From: ENVU Biodiversity and Land Use
Sent: 19 May 2025 09:21
To: Planning ContactCentre
Subject: 2025/90508 at location Lubrizol Ltd, Syngenta Ltd, Leeds Road, Huddersfield, HD2 1FE

Designations

Onsite habitats and species

BNG

HABITAT WORKS

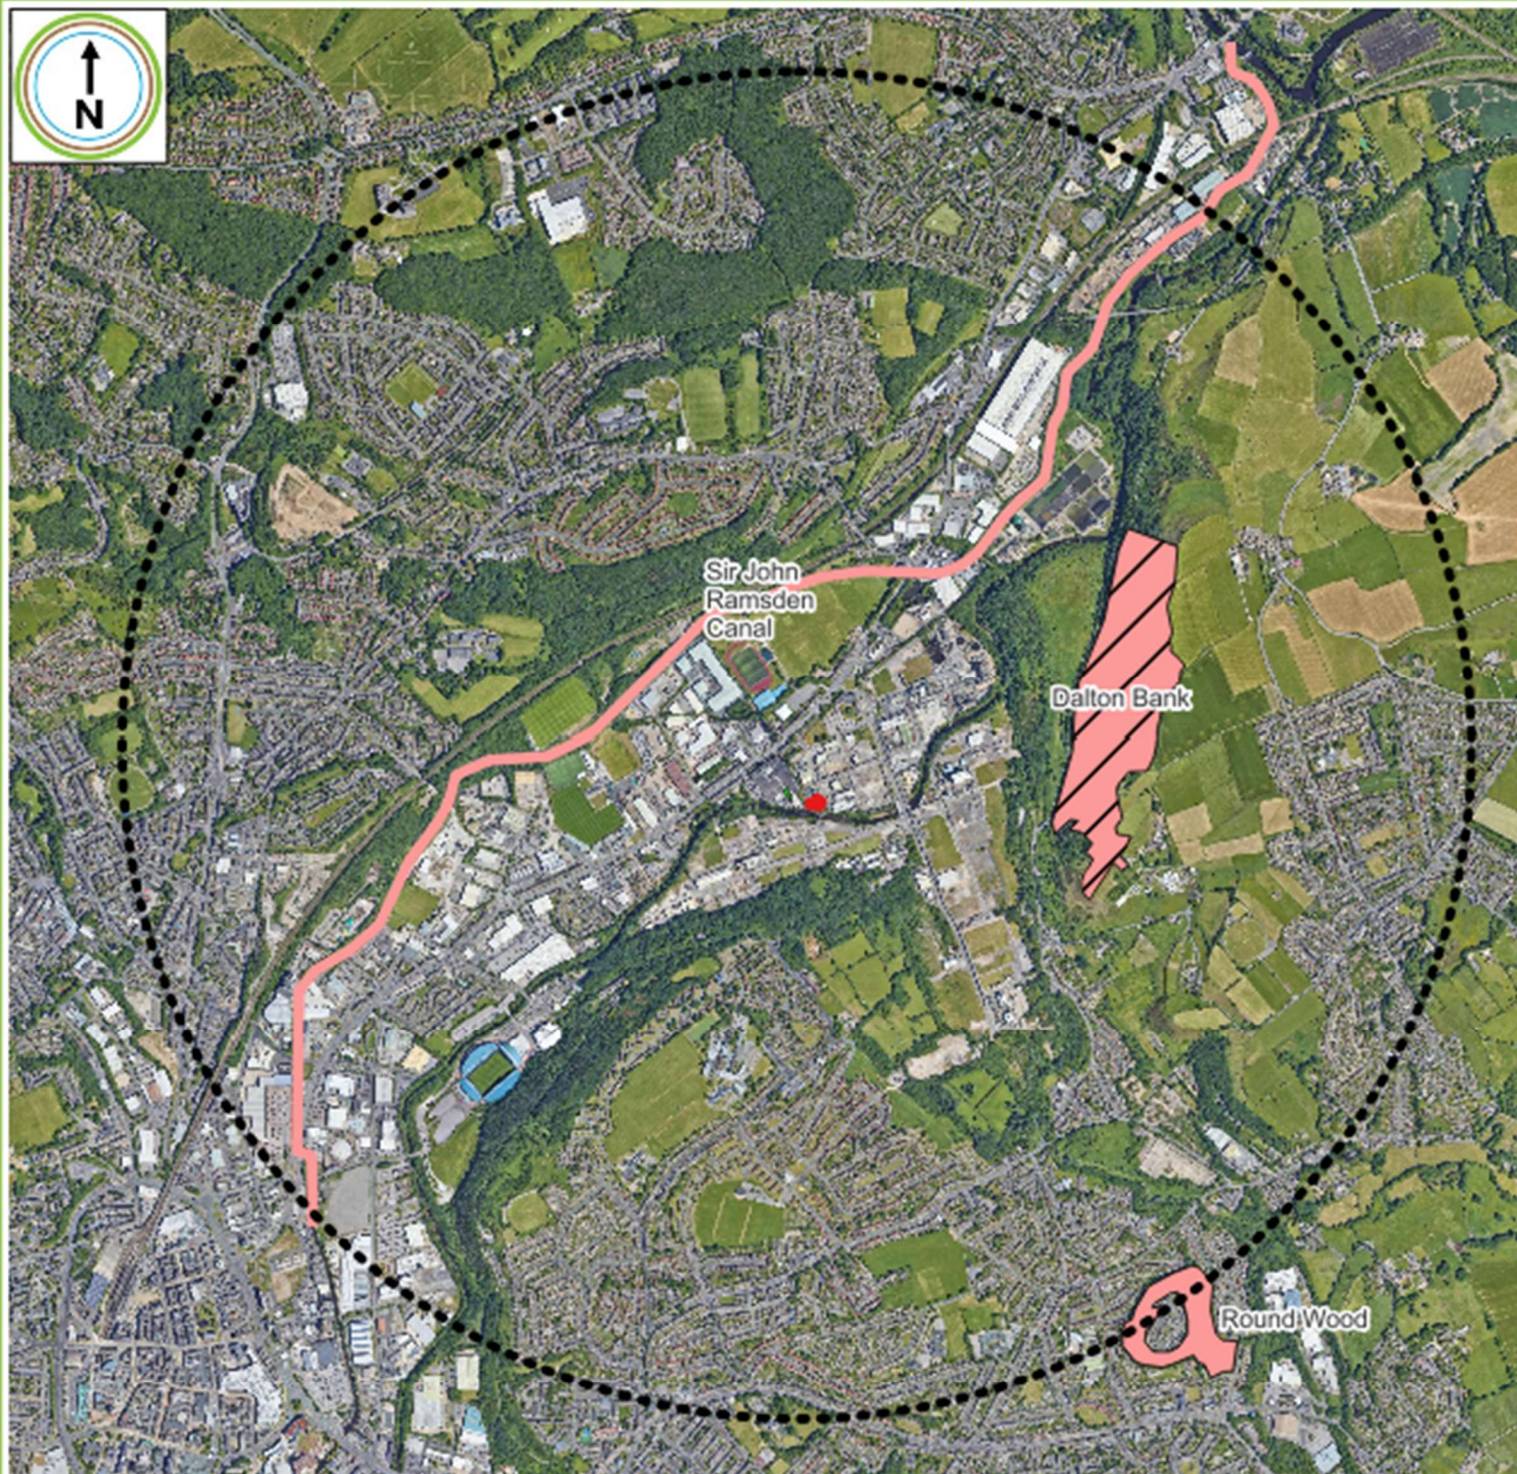
A Biodiversity Net Gain Assessment has been provided; however, this assessment shows a net loss, and the report shows no plan to make up for the shortfall. We recommend the applicant provides at least an outline of the intended route to achieving net gain.

A minimum of 0.22 habitat units will need to be achieved to ensure the development delivers a biodiversity net gain on site in accordance with Schedule 7A of the Town and Country Planning Act 1990. Currently there is a net loss of 0.2 low distinctiveness habitat units. For a site with such a low amount of biodiversity units at stake I would advise that the applicant provide a plan for achieving on-site net gain.
